## REQUEST

Current Zoning: I-2 (General Industrial)  
Proposed Zoning: MUDD(CD) (Mixed-Use Development District, Conditional)

Approximately 6.075 acres located on the north side of State Street, east of Ambassador Street, and west of Turner Avenue.

The petition proposes to redevelop an industrial property near the Seversville community with up to 450 multifamily dwellings and accessory uses.

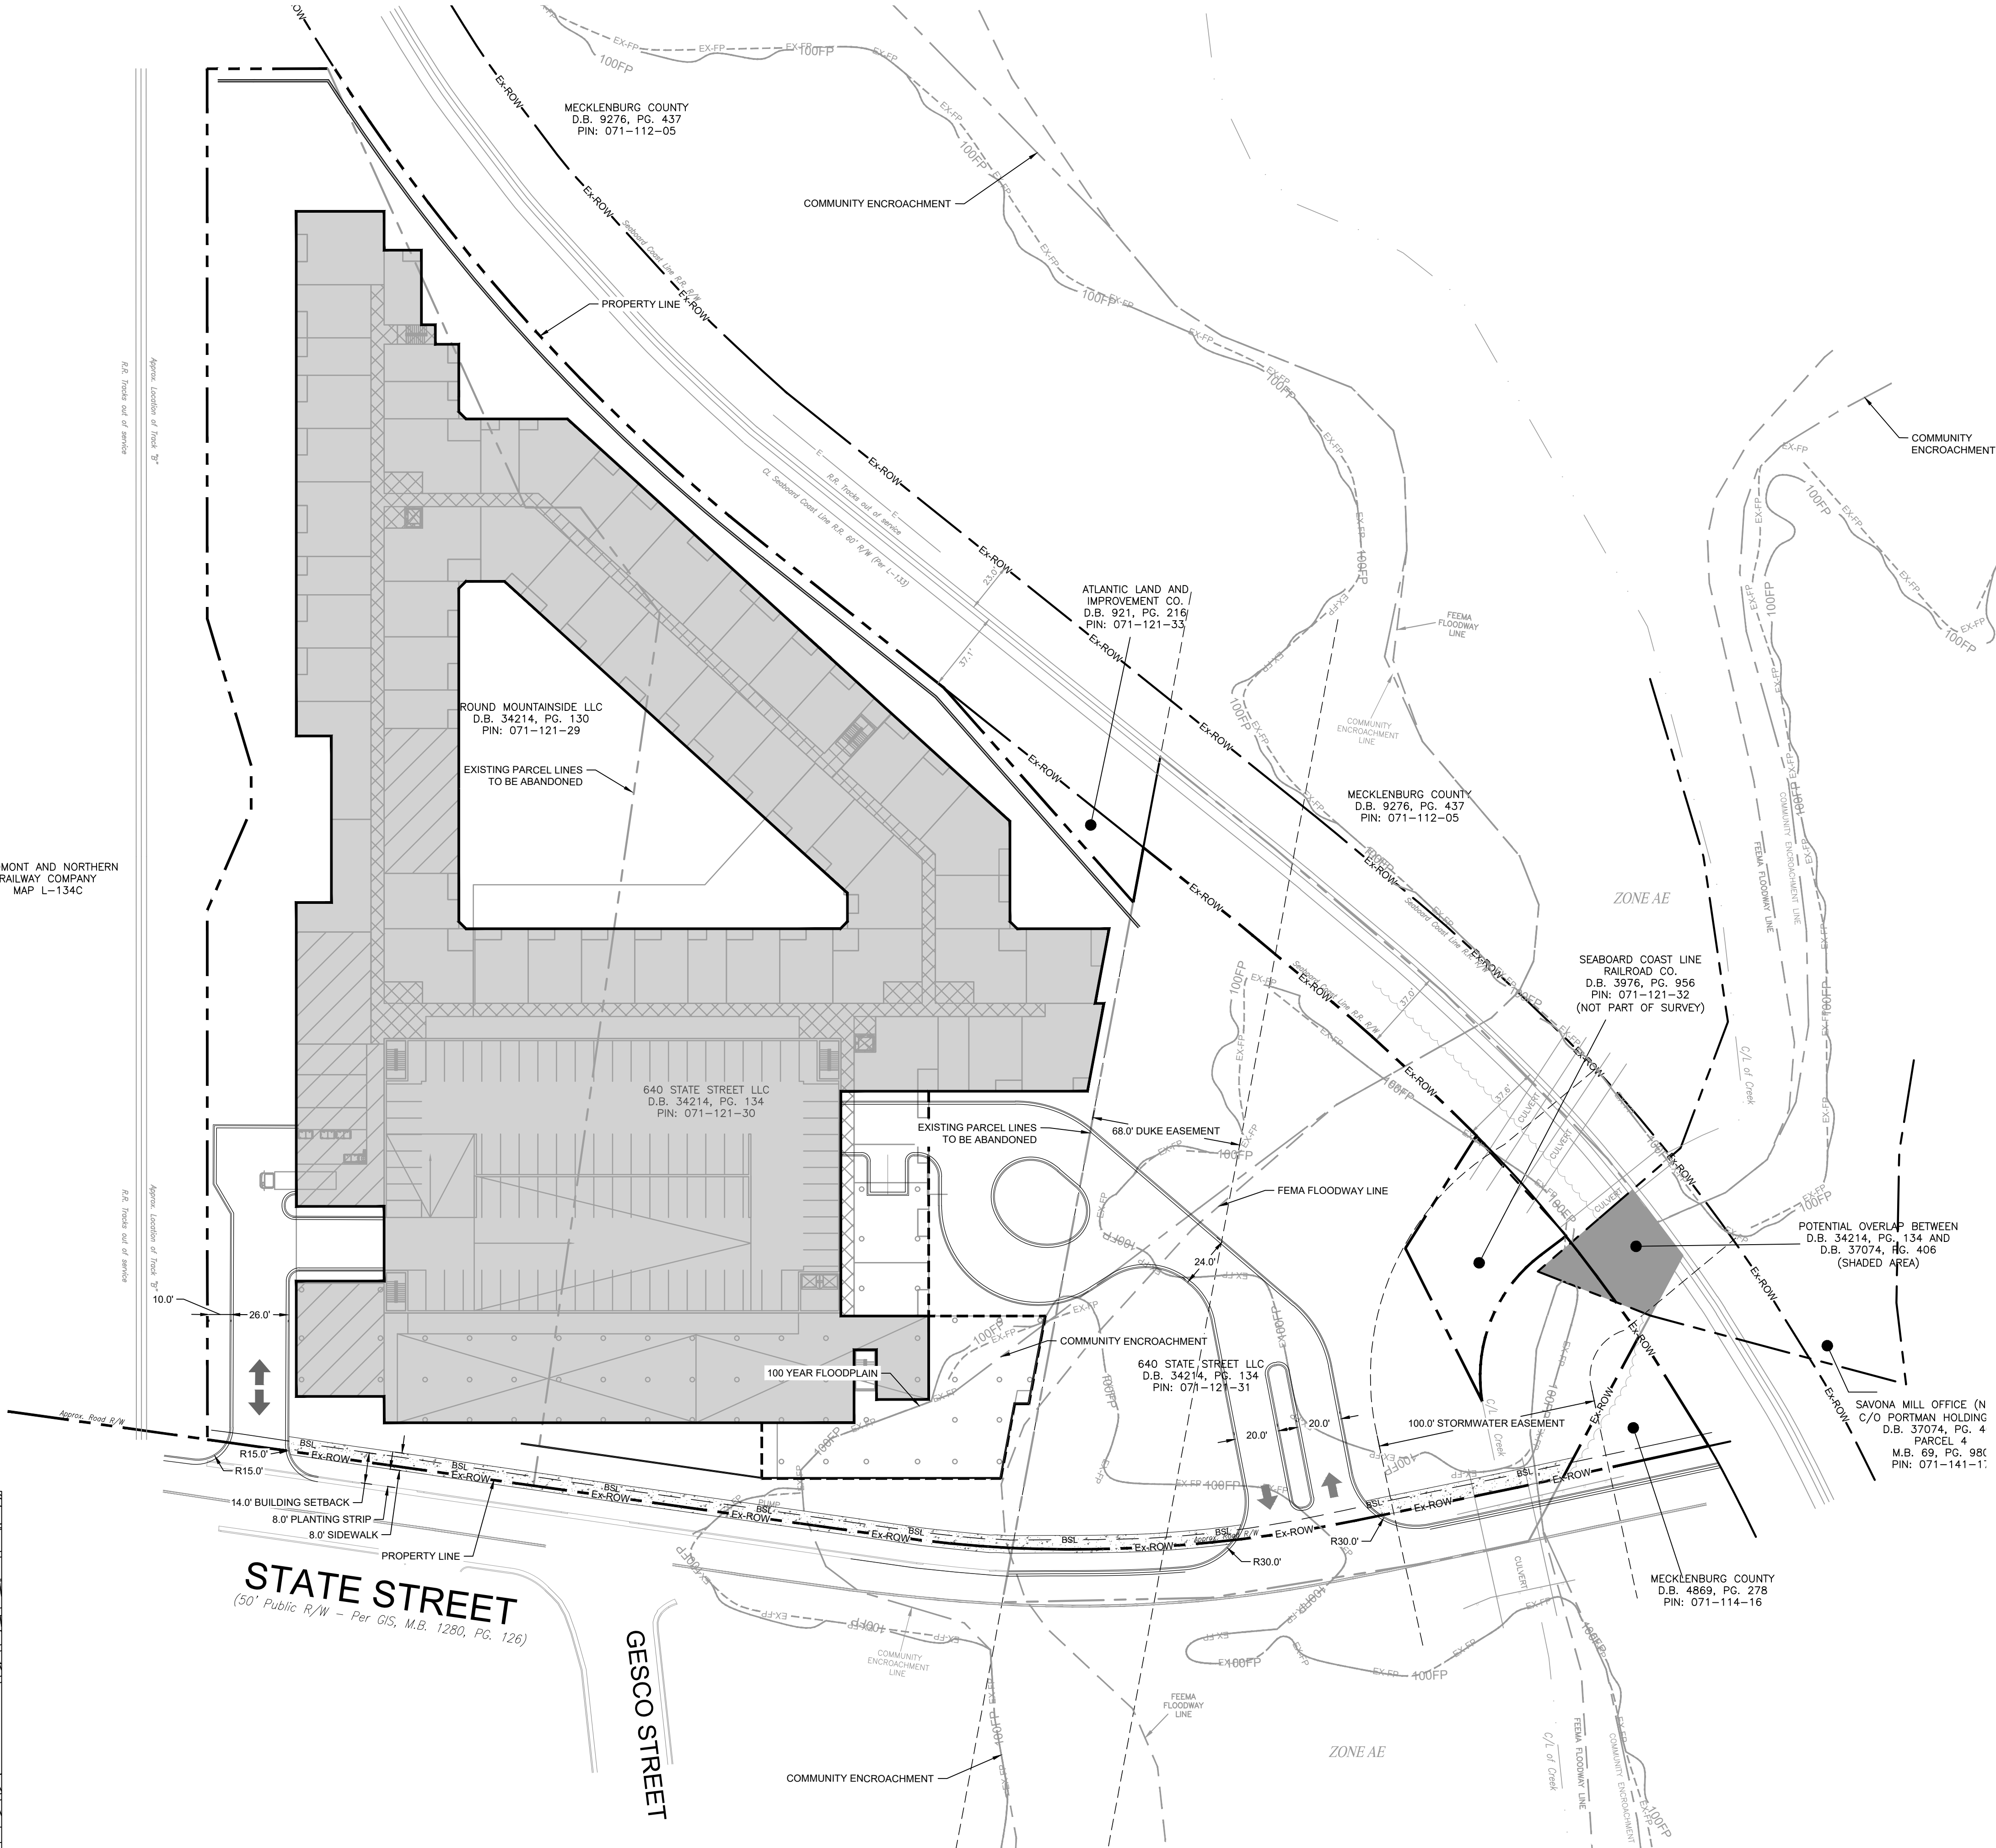
1. CDOT requests that the petitioner complete a Comprehensive Transportation Review (CTR) for the site for multimodal assessment and transportation demand management. As part of this request, the petitioner shall review and assess the publicly accessible pedestrian network within ¼ mile walking distance of the site to identify multimodal infrastructure to meet the Tier 3 (14 mitigation points) for multimodal assessment. As part of this request, the petitioner shall identify site-specific and development-related ways to reduce single occupant vehicle trips and encourage alternative modes of transportation to meet the Tier 3 (6 mitigation points) for TDM assessment.
2. Update Conditional note 3.F. and remove portion that states "under this section 3" as some of the transportation improvements are under other sections such as the streetscape.
